Application for a Non-Material Amendment Following a Grant of Planning Permission

Construction of one new dwelling; Partial demolition of existing dwelling and alterations including windows, doors and roofline; conversion of existing integral garage to form habitable rooms; landscaping including hard standing and widening of shared access, new pedestrian gate in wall and new fence.

22/07046/FU

Sheet Name: Proposed North & East Elevation - Project No: 8669

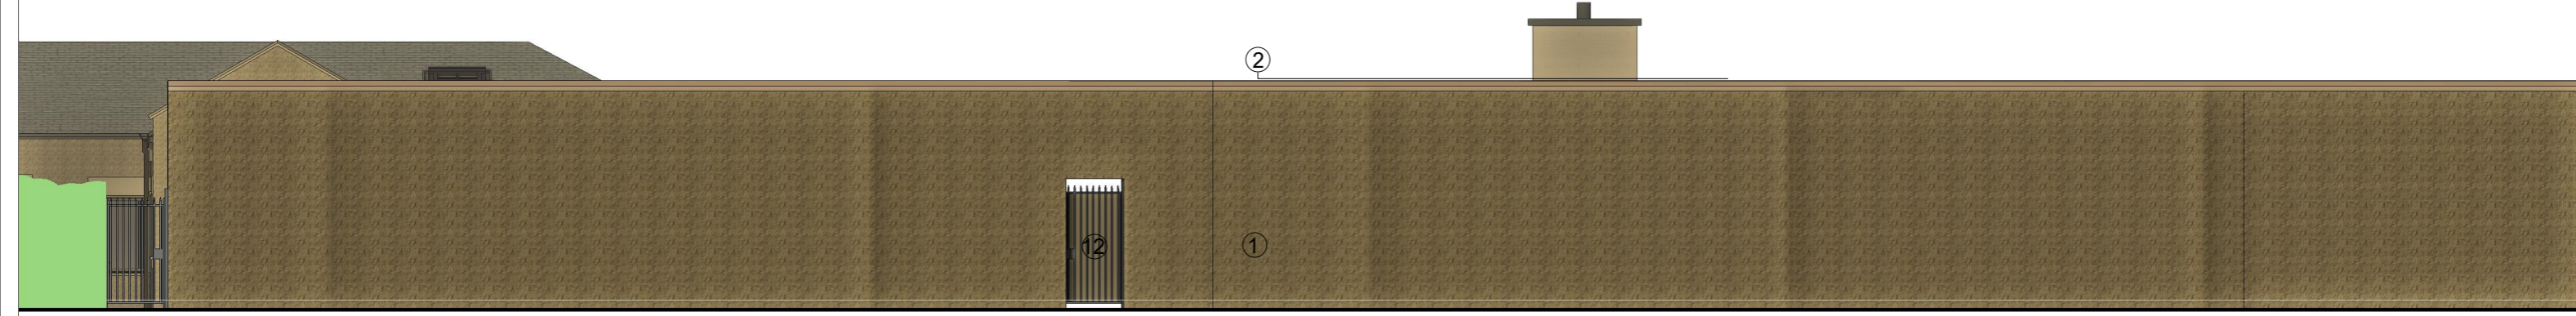
Re-positioning and re-sizing of windows and French doors to the East elevation (front of the property), and a re-positioning of the front door.
Re-positioning and re-sizing of windows and French doors to the West elevation (rear, garden-facing side of the property), and some changes to materials.
Update to the window layout of the South elevation (side of the property), and changes to materials for garage doors.
Minor re-design of building footprint. Interior layout reconfiguration with re-positioned exterior windows / doors to support this. Re-location of pedestrian gate slightly to the east.
Updated roof plan, connecting the house to the garage for enhanced amenity / aesthetic and to allow for an extended solar panel plan.
Updated skylight layout in support of the updated interior layout.
